Re: Objection to MP08_0244 MOD 1 Modification Request for Mixed Used Development at 23-37 Lindfield Avenue and 11 Havilah Lane, Lindfield

ELEVATIONS

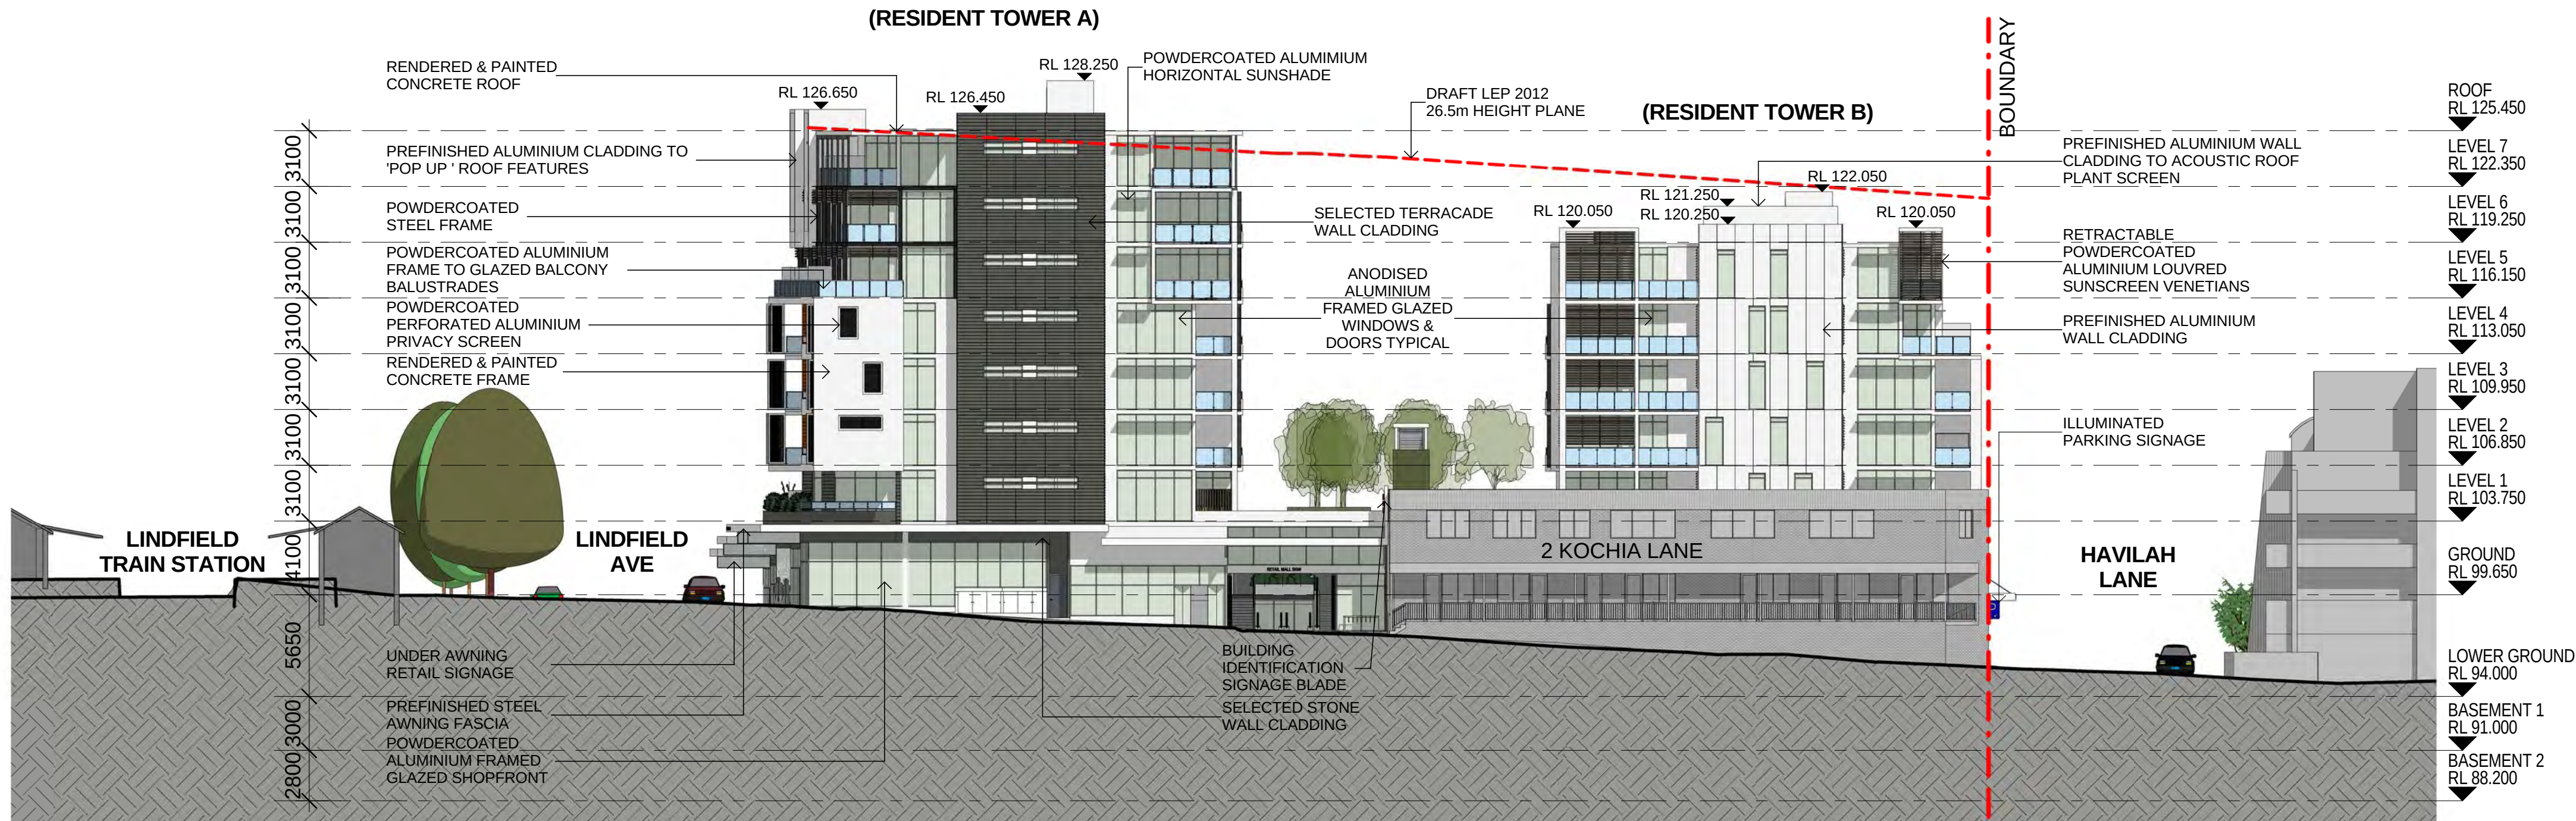
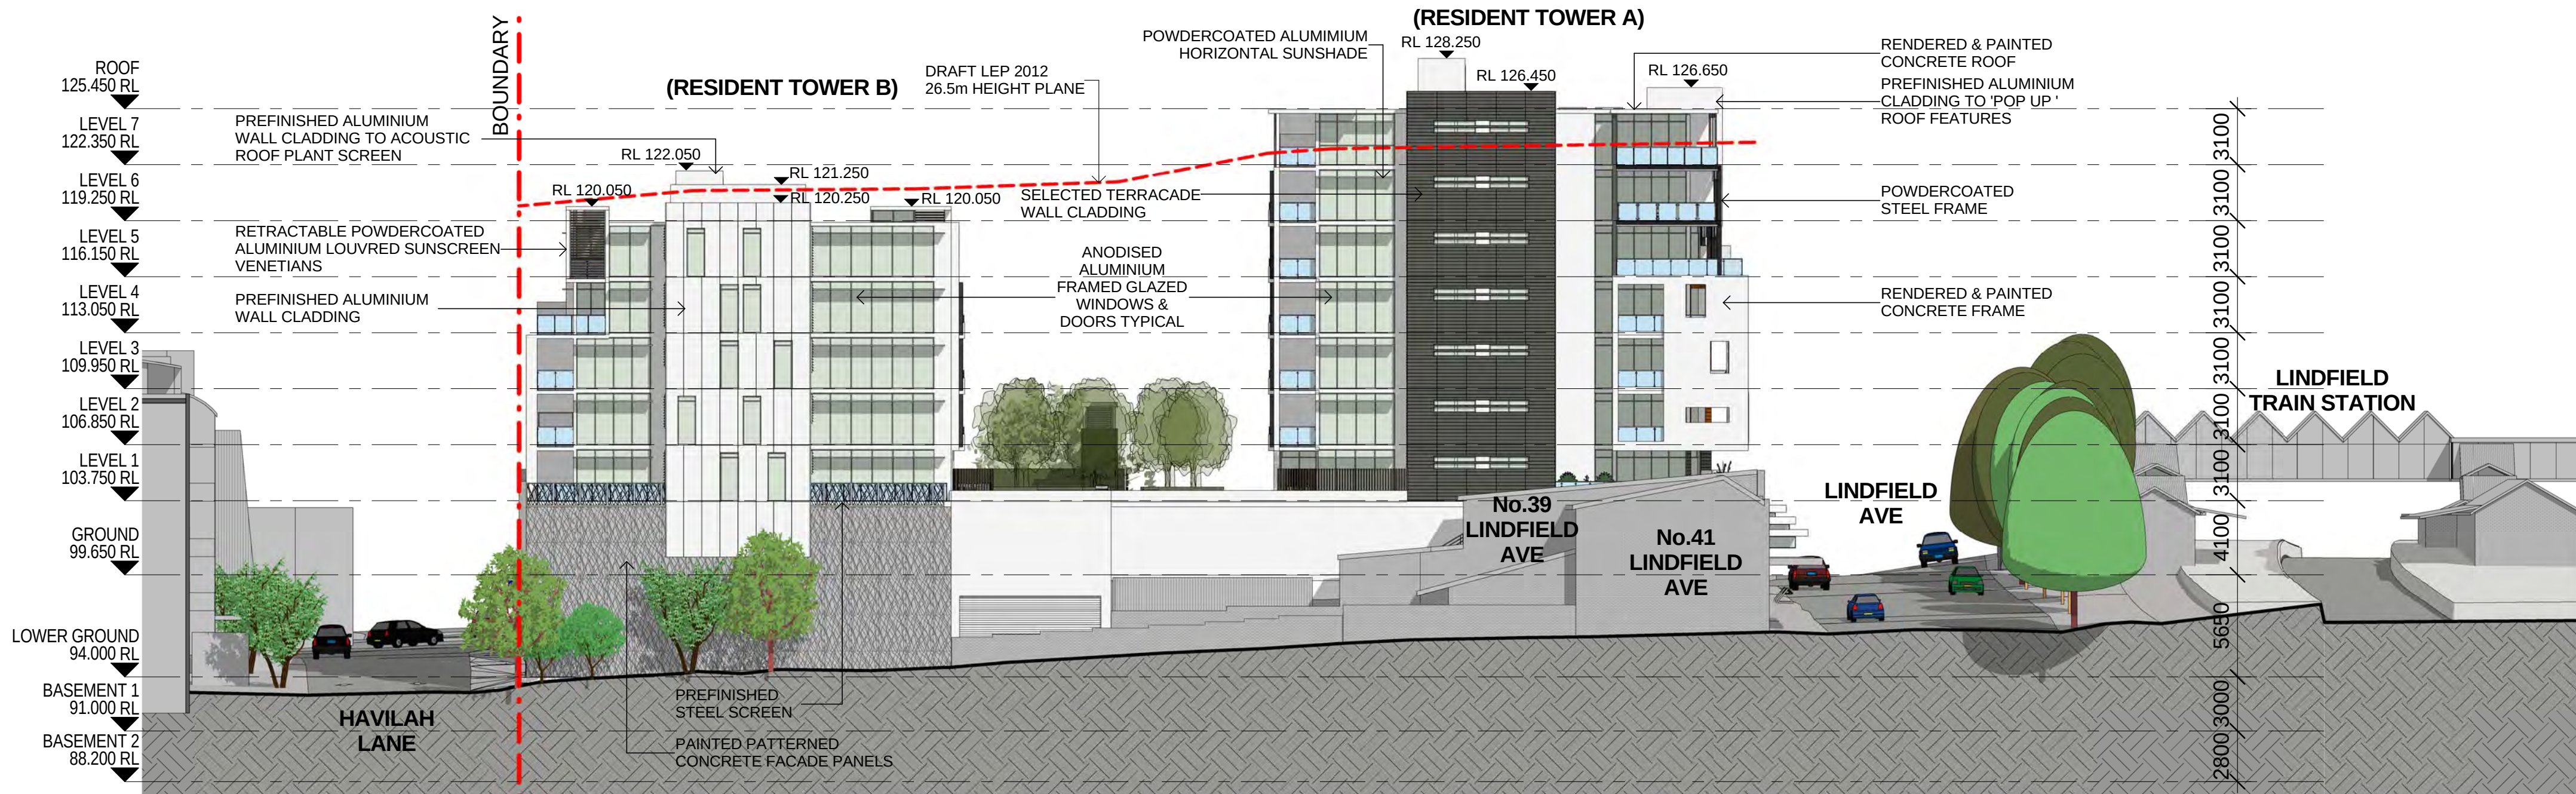
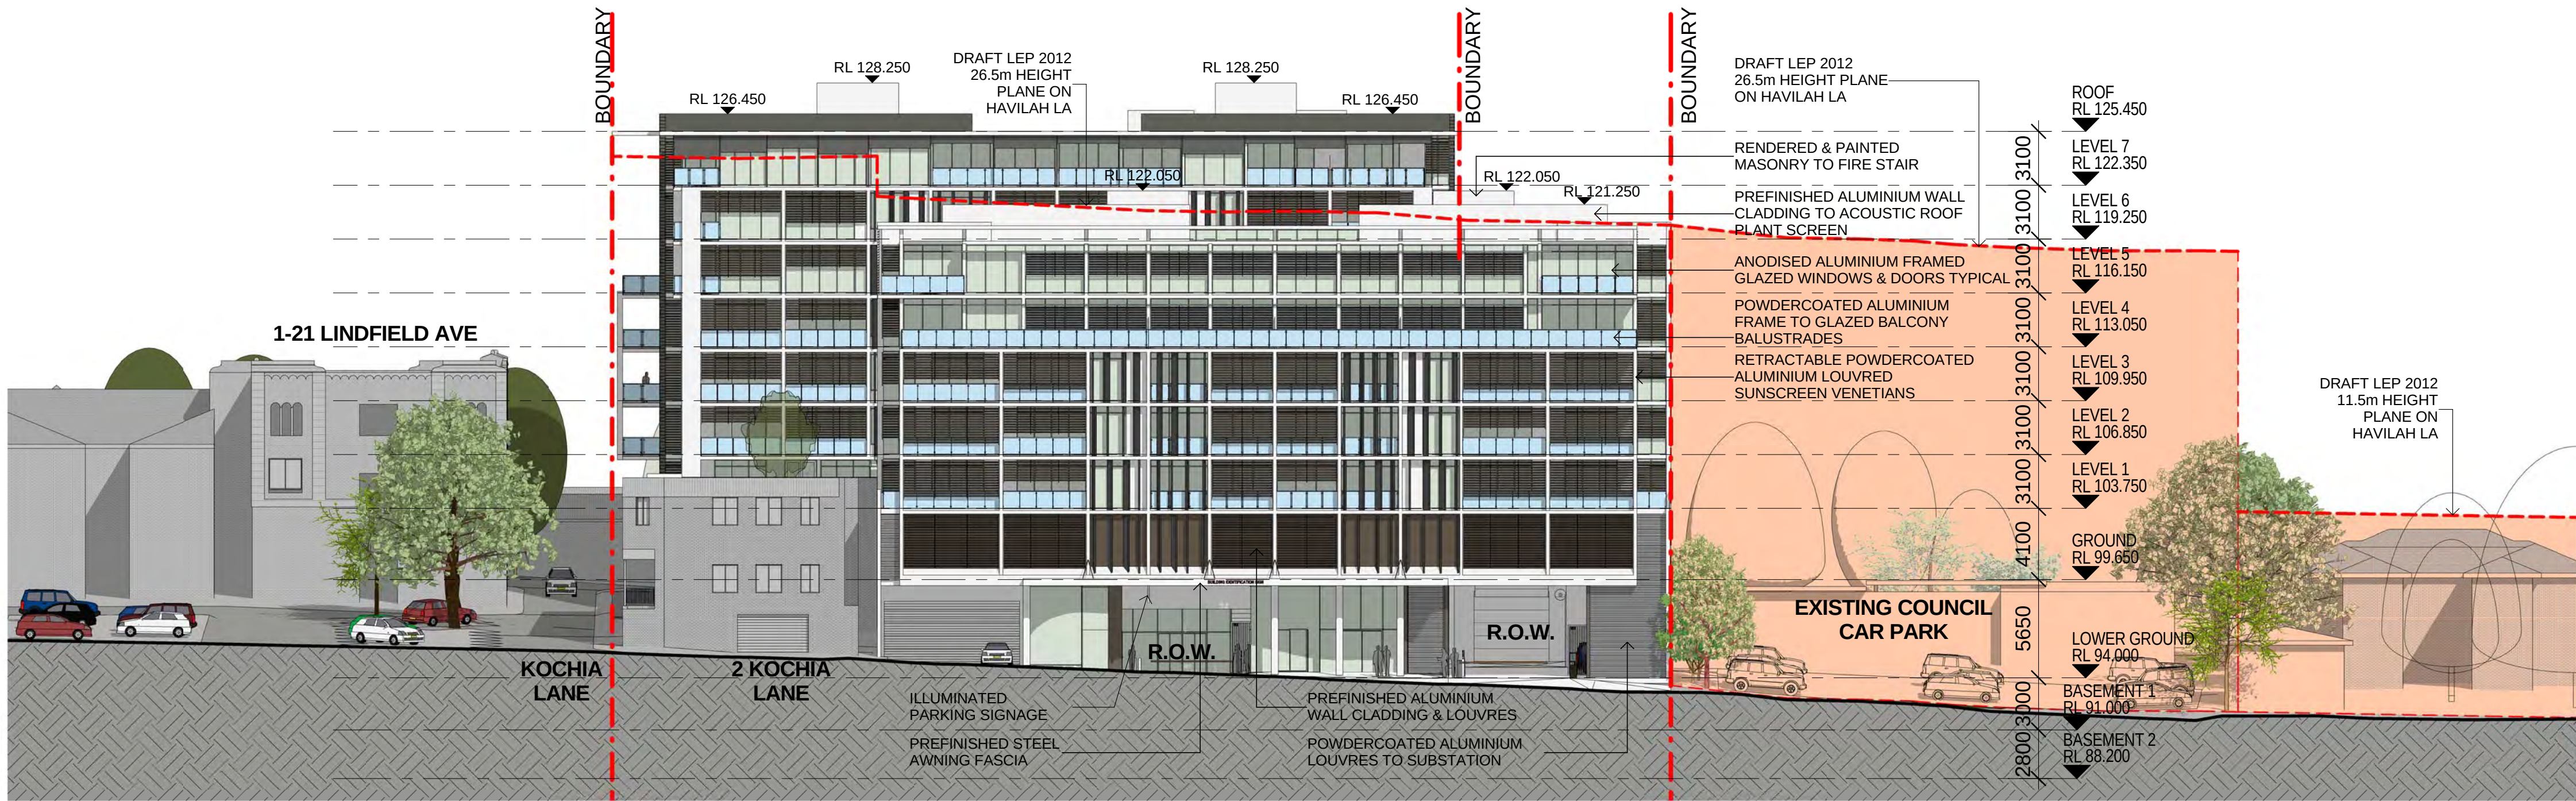
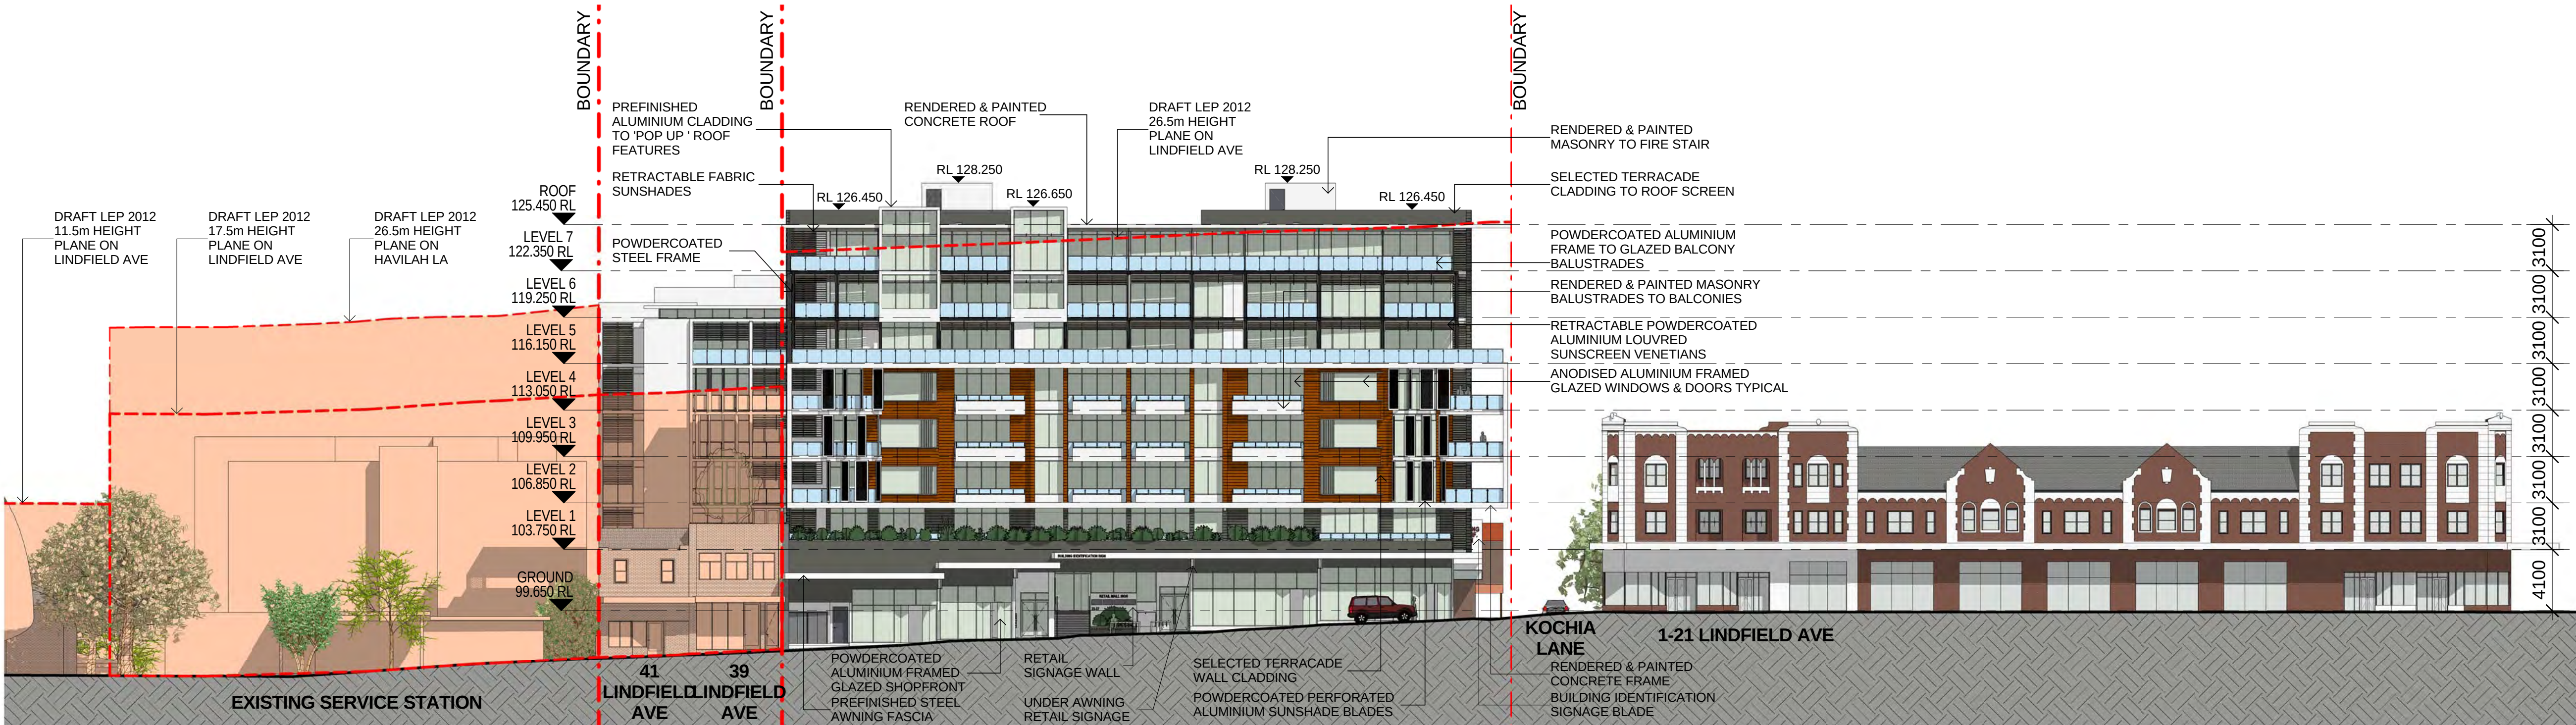
- The Increase of an additional storey to both buildings: 8 storeys on Lindfield Avenue and 7 storeys on Havilah Lane creates excessive height and bulk and is out of character with the surrounding buildings, including the heritage listed adjacent building on Lindfield Avenue

- The additional storey (combined with less set back than the approved design) on Havilah Lane now creates privacy concerns for over 40 apartments in the adjacent 8 Havilah Lane, 8 Kochia Lane and 2-8 Milray Street residences
